**Cory Decarbonisation Project**

**Planning Inspectorate Reference: EN010128**

**SAVE CROSSNESS NATURE RESERVE**

**Deadline 2: Comments on further information and  
submissions received at Deadline 1**

# ACCESS AND RIGHTS OF WAY PLANS: 2.4

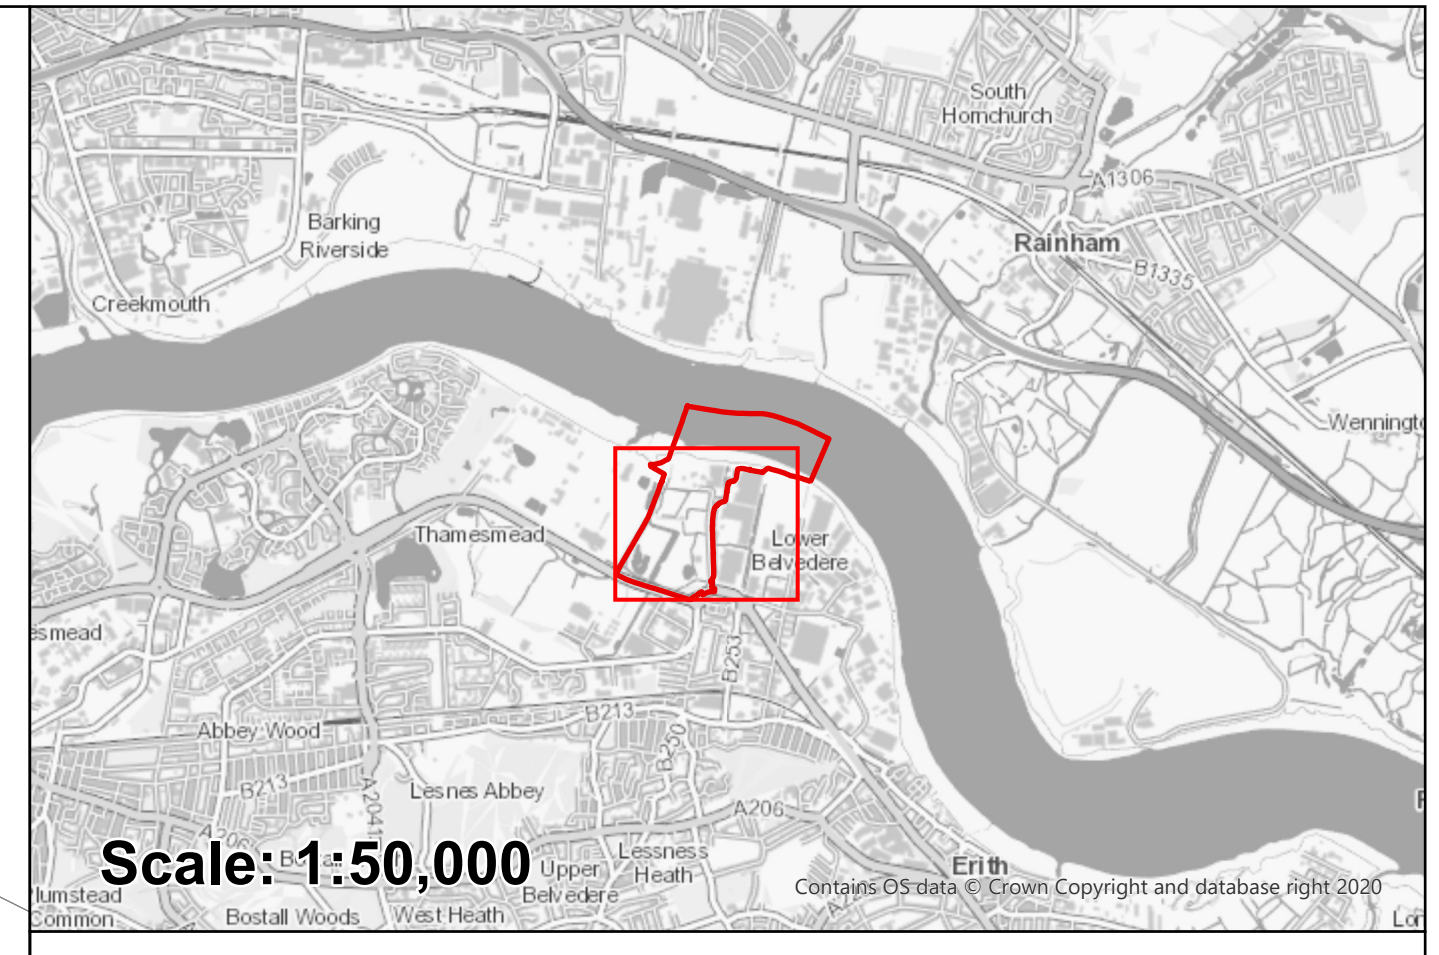
16. We take particular issue to the proposed PRow in the north-west corner of the Site, creating a second route between FP2 and FP3. This route is redundant given the existing route to the west that serves the same purpose. It will lead to completely unnecessary fragmentation of and harm to habitat, while offering no meaningful benefit.
17. The Applicant's Written Summary of Oral Submissions at ISH1 confirms that the exact routes and detailed design of the new and altered PRows are not yet determined. Until this information is prepared, the full extent of the potential ecological harm, and

20. The Applicant continues to overstate the harm to FP4 if the Carbon Capture Facility were delivered in the East Zone. The Applicant's East Zone Connectivity Note only confirms that all the problems listed are either resolvable, or ultimately do not create a significant amount of harm, especially when compared to the loss of Crossness Nature Reserve Land under the Proposed Scheme. The potential effect on the linear green and blue infrastructure along Norman Road is obviously far less significant than the actual loss of the more valuable Crossness Nature Reserve land.

21. The impacts on users of FP4 are overstated. It is common to have vehicle crossings on public footpaths – in fact, FP1 even crosses a busy dual carriageway (the A2016 Eastern Way).

22. The fact that a small part of FP4 would “*feel significantly more industrial in character*” is of minor concern, and to be expected when surrounded by SIL. Furthermore, as per Figure 1 above, these concerns could be improved through a rerouting of FP4 along the southern and eastern edges of the Carbon Capture Facility.
